# Final Drainage Report

## Townhomes at Western

Lot 1, Cimarron Southeast Filing  
No. 2C

PPR2415

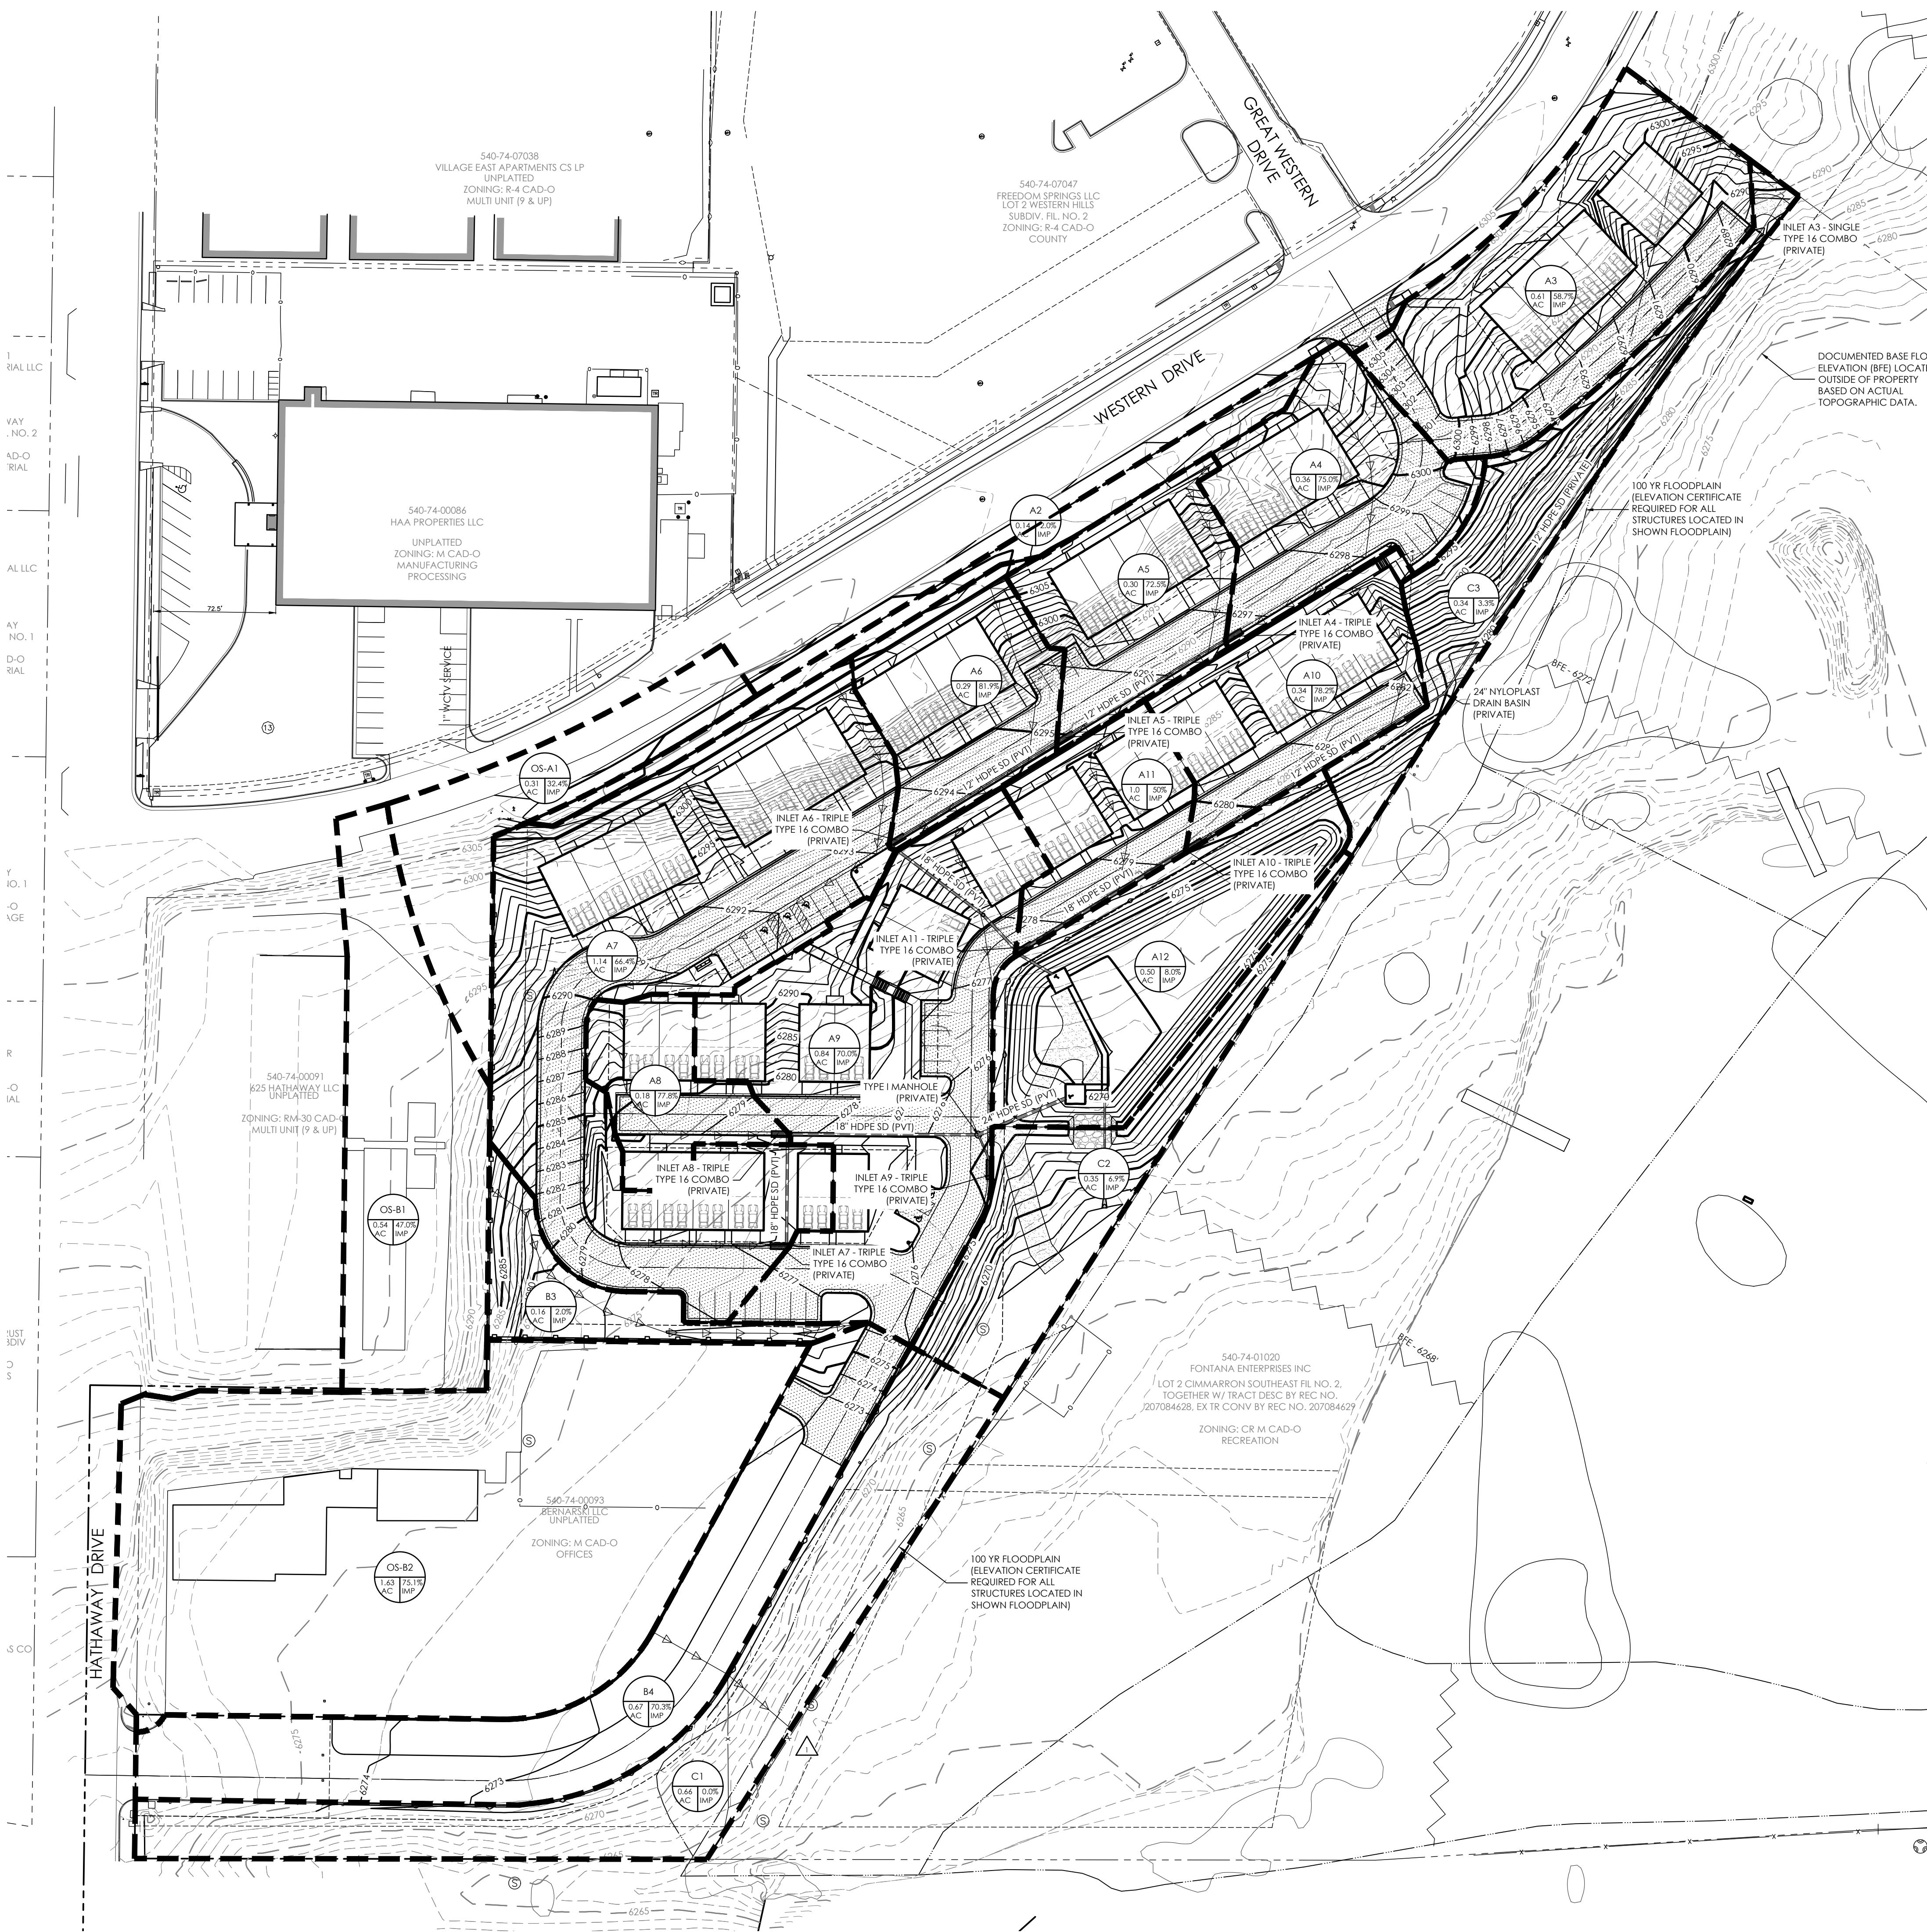
The existing drainage patterns of the Townhomes at Western are described by three off-site and three on-site drainage basins. These basins are previously disturbed or developed to a degree as described below. All existing basin delineations and data are depicted on the attached Existing Drainage Map. Drainage map shows 4 onsite basins.

Include discussion of Basin EX-B3 and the 3 offsite basins
